From: Kathryn Welch
Sent: 22 December 2021 10:09
To: Planning.Responses
Subject: FW: EP/142/21/HH 38, Vermont Drive, East Preston
Attachments: 38 Vermont Drive East Preston FF PLANS.pdf; 38 Vermont Drive East Preston BLOCK PLAN.pdf; 38 Vermont Drive East Preston GF PLANS.pdf; 38 Vermont Drive East Preston PROP ELEVS.pdf; Action Sheet v3.docx

From: [REDACTED]
Sent: 21 December 2021 17:54
To: Kathryn Welch <Kathryn.Welch@arun.gov.uk>
Subject: EP/142/21/HH 38, Vermont Drive, East Preston

Please find attached revised GF plans, FF plans & elevations for the above.

ARW Design	DRAWING TITLE:	LOCATION:	SCALE:
	PROPOSED ELEVATIONS	38, VERMONT DRIVE, EAST PRESTON	
	PROJECT:	CLIENT:	
PROPOSED LOFT CONVERSION WITH HIP TO GABLE END & DORMERS TO SIDE ELEVATIONS		C. NORTH	AS NOTED @ paper size A3
			DATE:
			OCT 2021
		DRAWN:	DRAWING NO:
		ARW	
		REVISION:	6037/2
		a

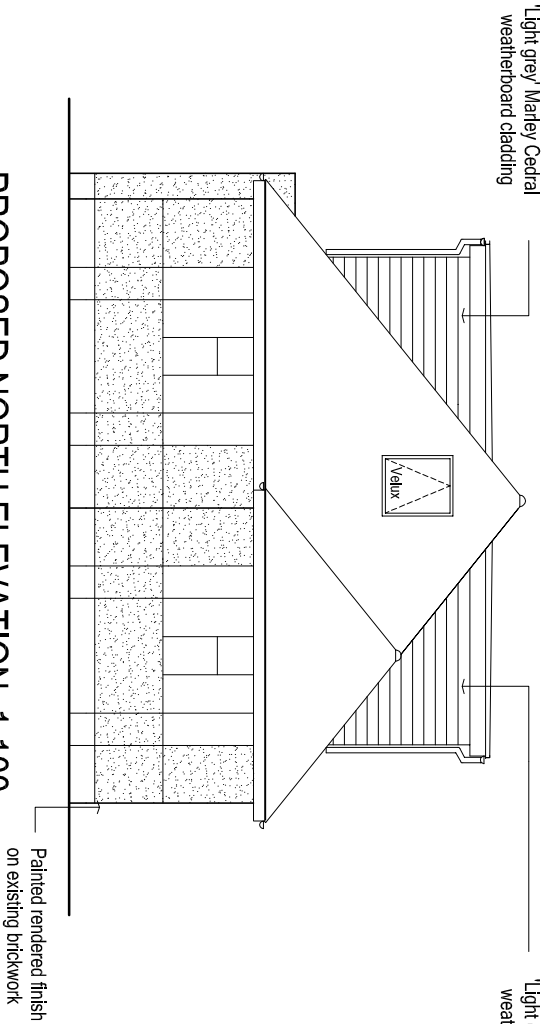
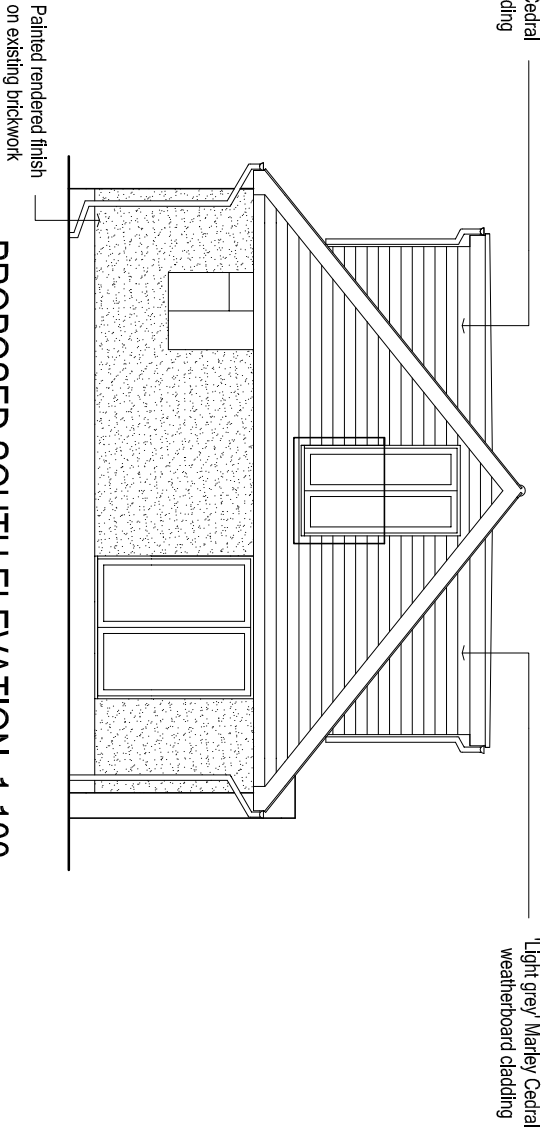
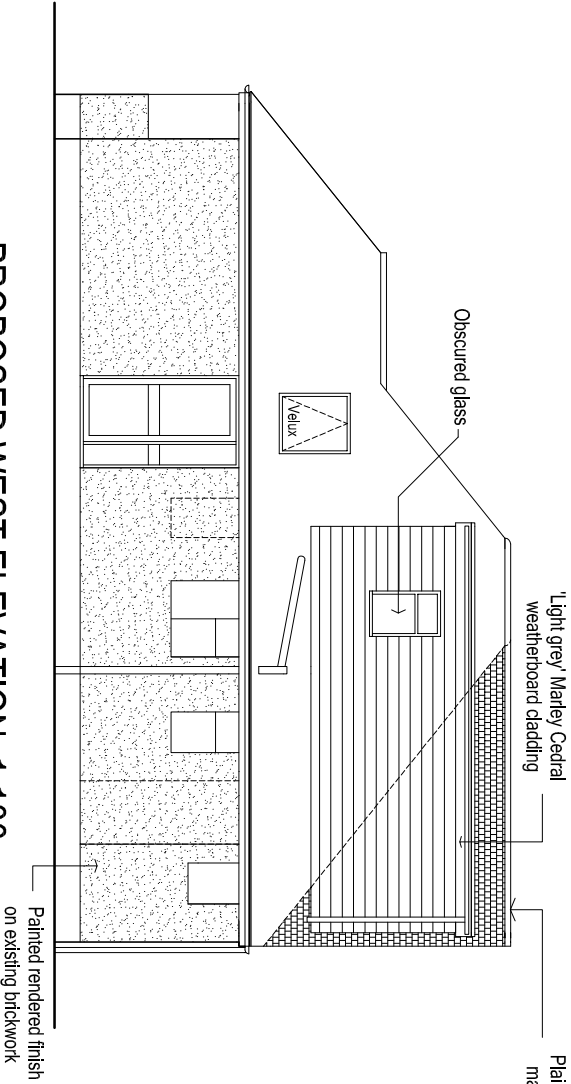
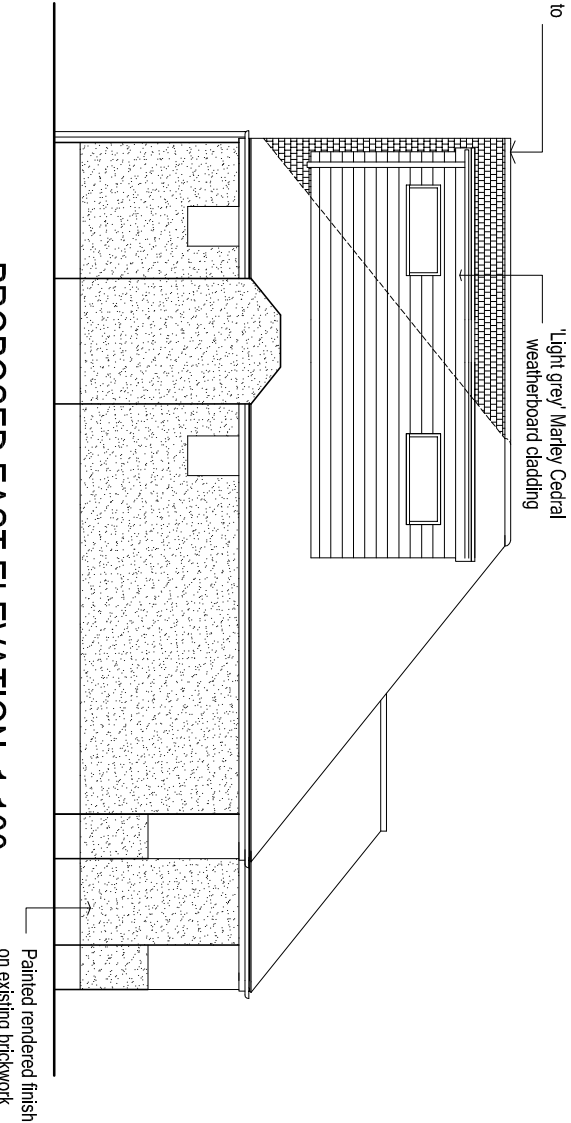
As you will see I have reduced the volume of side dormers & removed the west elevation window.

This brings the project within Permitted Development. However the Marley Cladding to dormers & rear gable end together with all existing & new windows & fascia's being replaced with Anthracite UPVC & finally the addition of painted rendered finish to all existing walls at ground level.
